**Saint Ignatius College Riverview Redevelopment Stage 2 (SSD-10424)  
Response to Submissions**

## ATTACHMENT 1 – KEY ISSUES

Figure 2. Overlay of Stage 2 and approved Concept Proposal (Source: PMDL Architects, 2021)

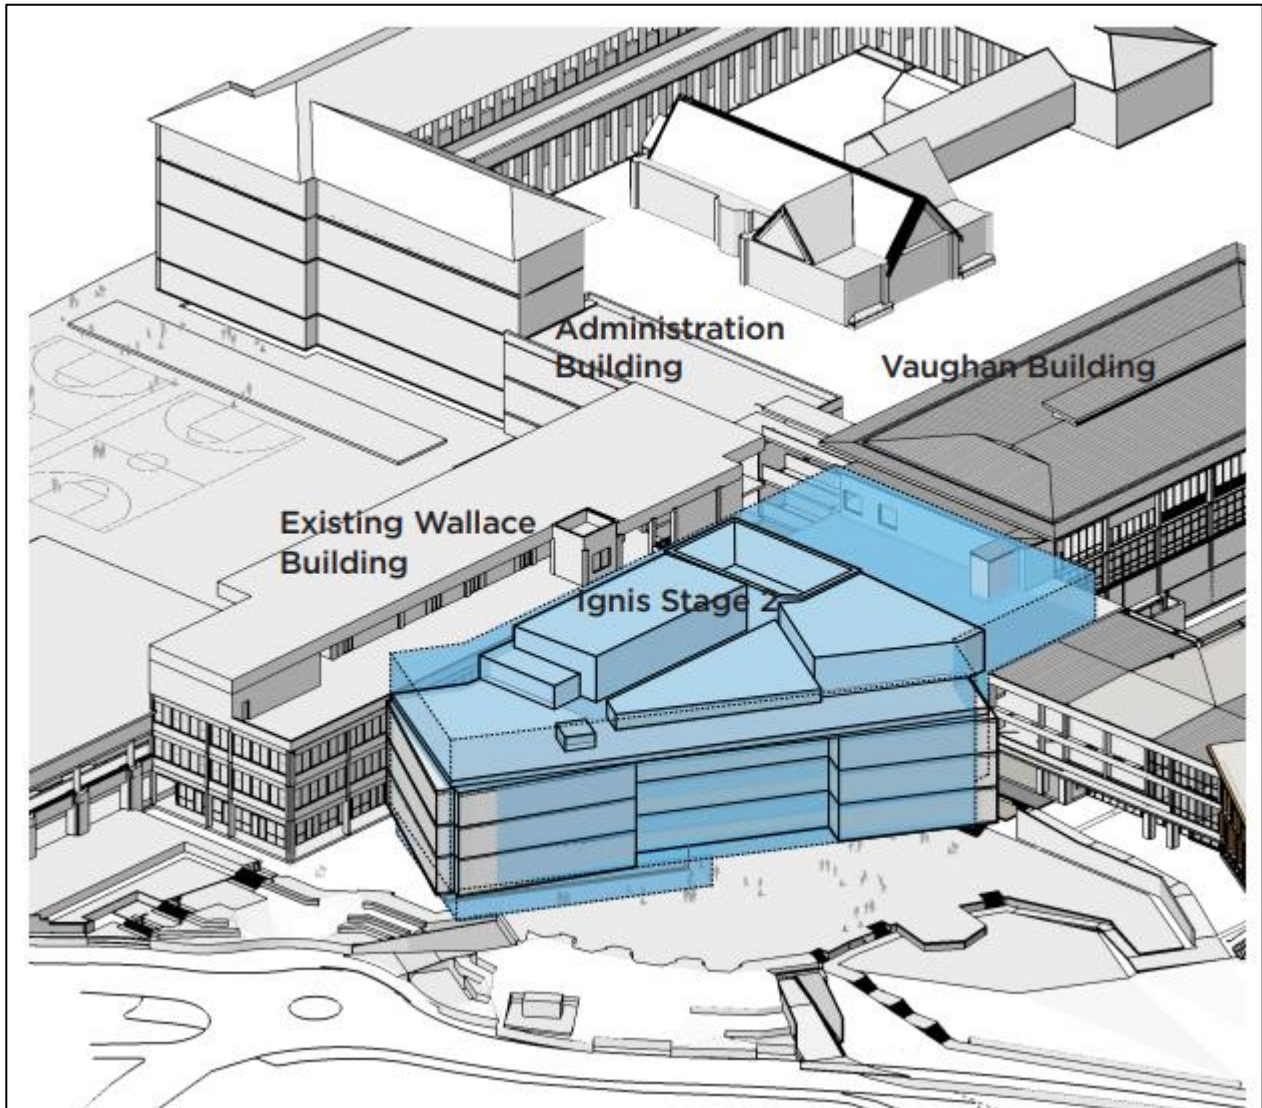
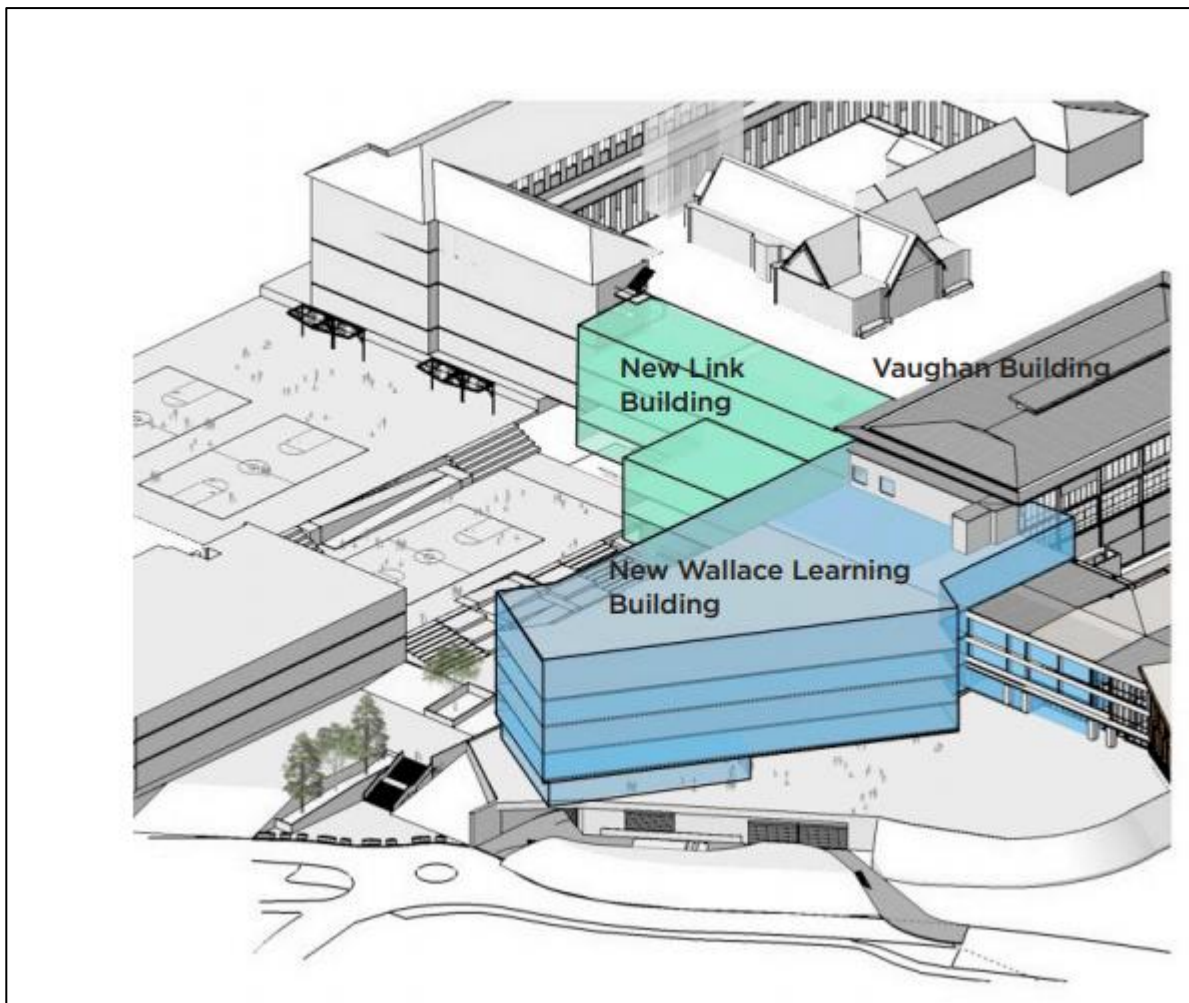
- provide a table to indicate how this application complies with the conditions of consent for the Concept Proposal.
  - overlay the Stage 2 detailed plans over the Concept Proposal site layout to demonstrate compliance (or non-compliances) between the proposed and the approved site layouts.
